**Re:** Planning Application 18/0913

**Address:** Land off Clitheroe Road adj Shaw House Farm BB7 9AD

**Description:** Installation of a backup electrical generation hub together with security fencing, access, substations, gas kiosk and associated plant and equipment.

## SHAWHOUSE, WHALLEY - SITE LAYOUT

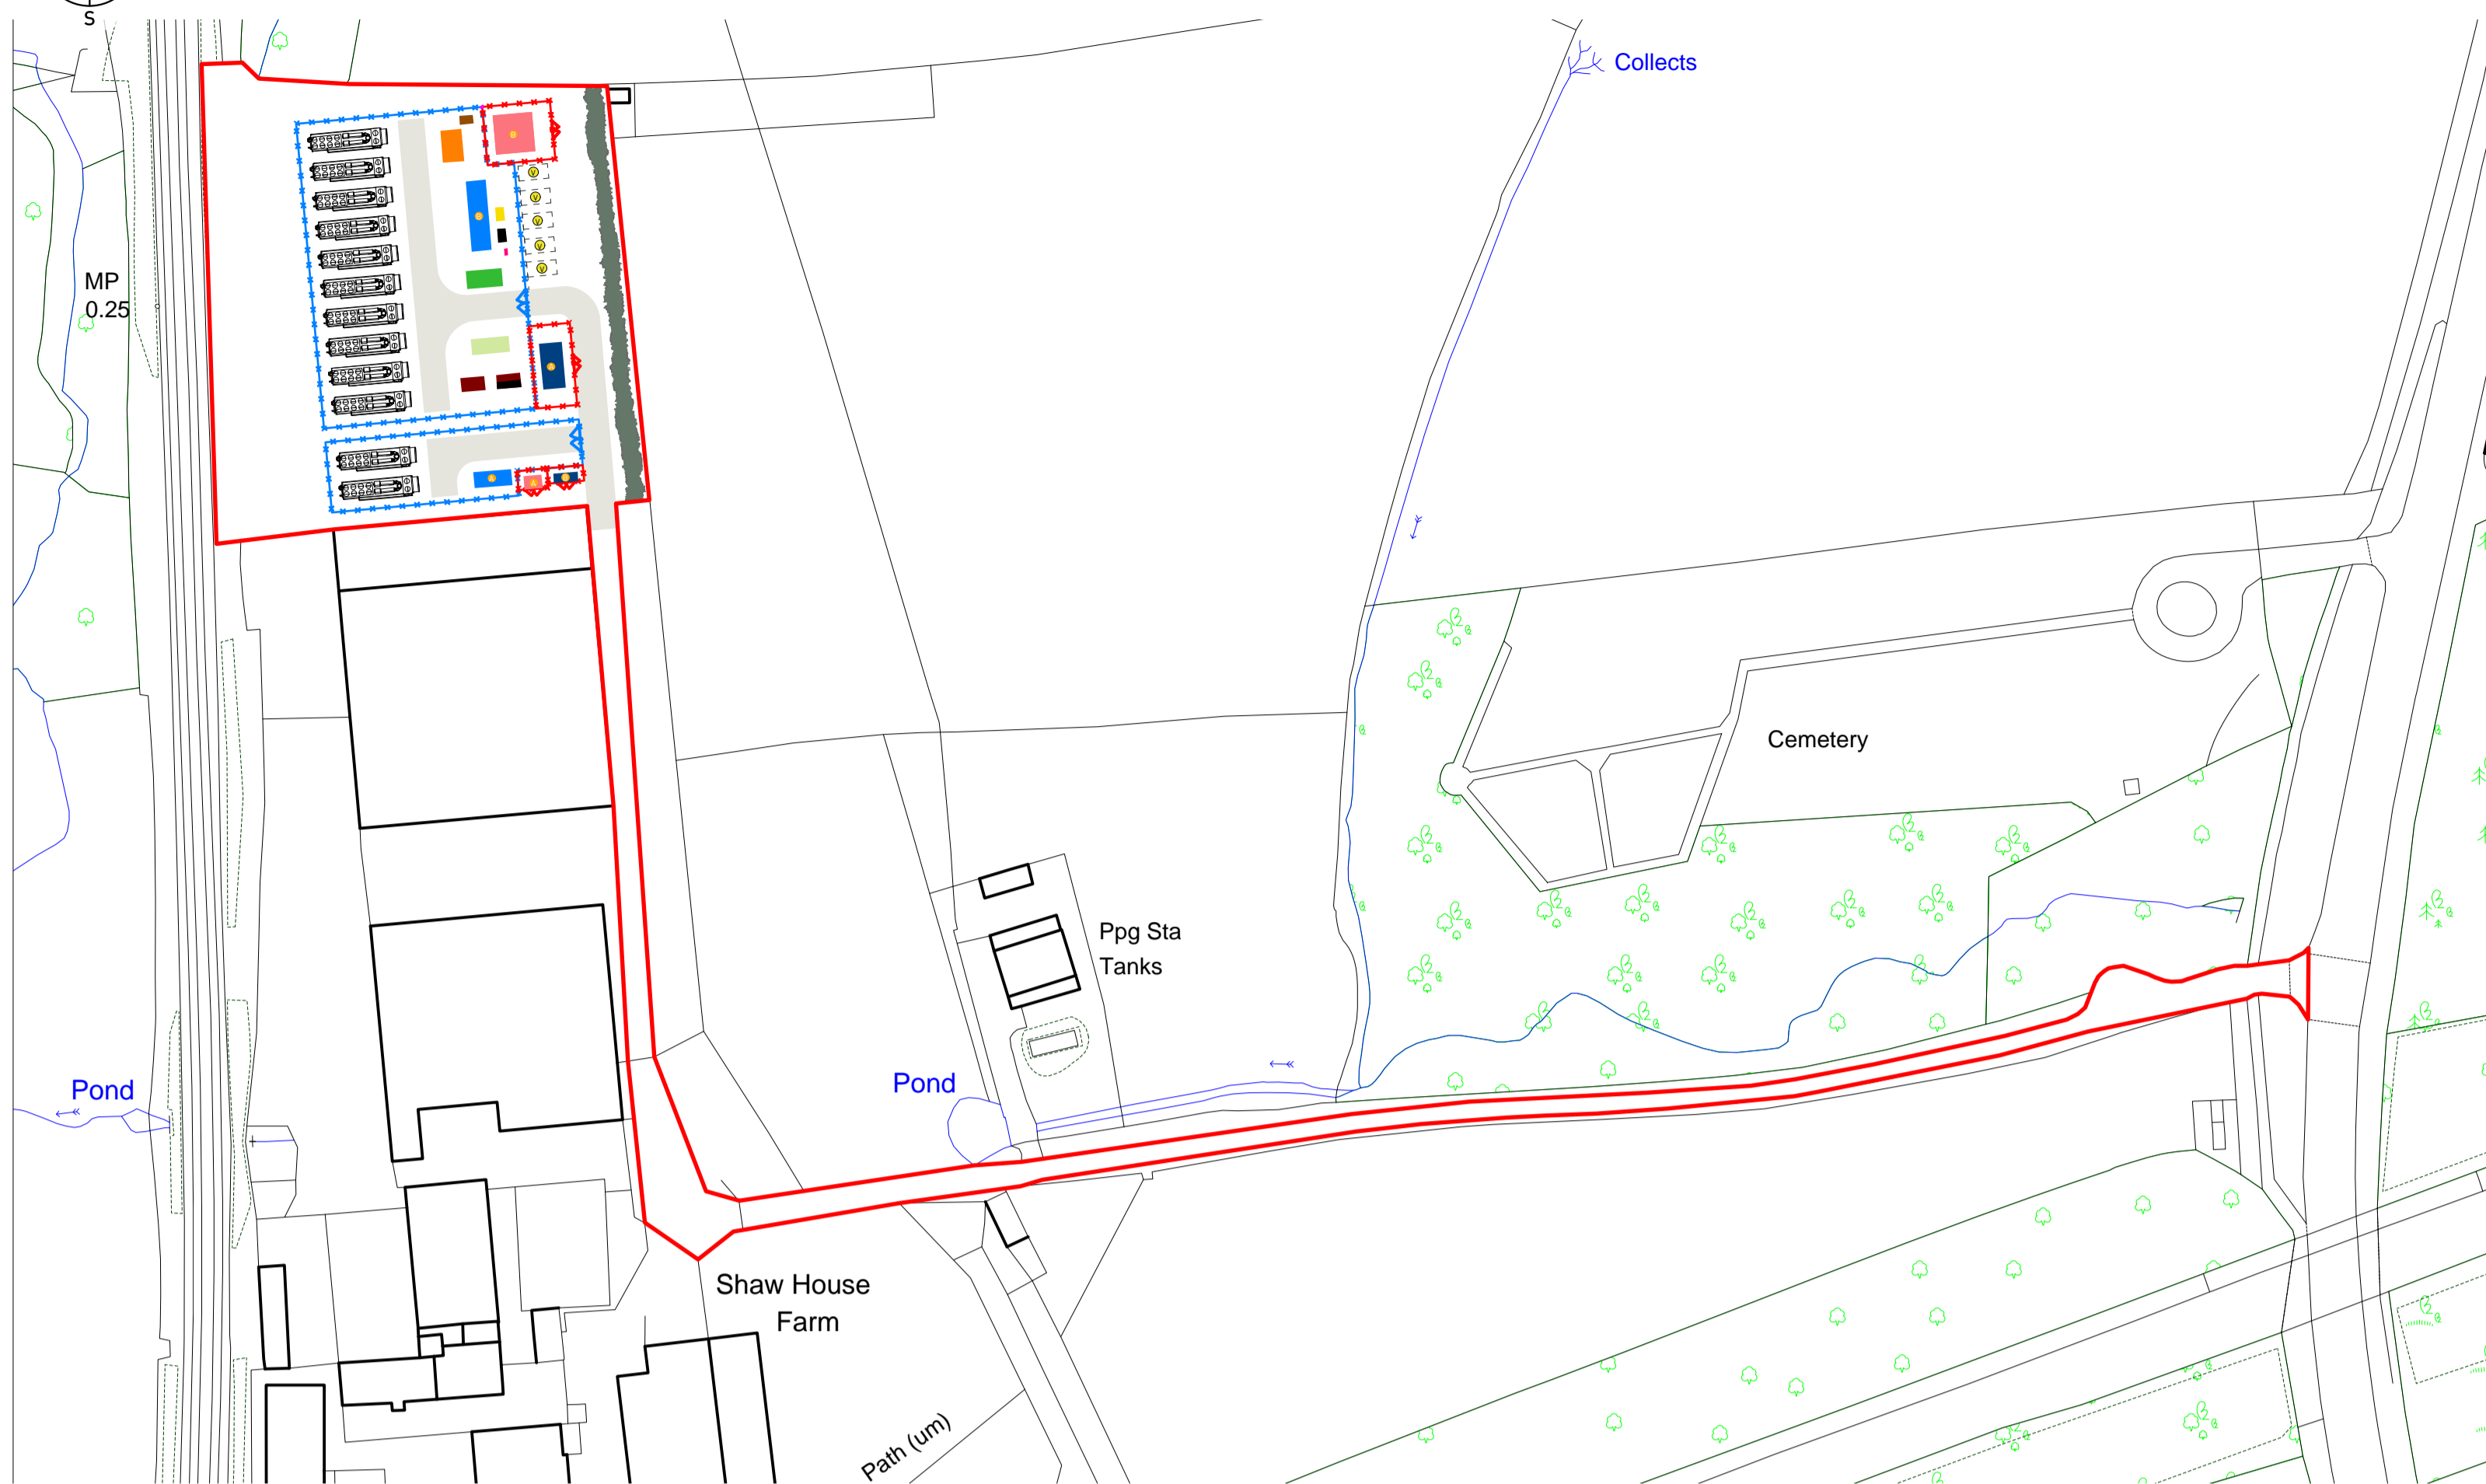
Additionally, there is a concern regarding the delivery of materials and machinery to the site, the access lane is narrow and a clear view cannot be made along its full length which is in excess of 250m. Consideration as to how the management of the access and egress of vehicles from the site can be achieved should be given.

1. The grant of planning permission does not entitle a developer to obstruct a right of way and any proposed stopping-up or diversion of a right of way should be the subject of an Order under the appropriate Act. Further details can be found by contacting [PROWplanning@lancashire.gov.uk](mailto:PROWplanning@lancashire.gov.uk)
2. No development shall take place, including any works of demolition, until a construction method statement has been submitted to and approved in writing by the Local Planning Authority. The approved statement shall be adhered to throughout the construction period. It shall provide for:

- i) The parking of vehicles of site operatives and visitors

- ii) The loading and unloading of plant and materials
- iii) The storage of plant and materials used in constructing the development
- iv) The erection and maintenance of security hoarding
- v) Wheel washing facilities and road sweeping as required
- vi) Measures to control the emission of dust and dirt during construction
- vii) A scheme for recycling/disposing of waste resulting from demolition and construction works
- viii) Details of working hours
- ix) Routing of delivery vehicles to/from site
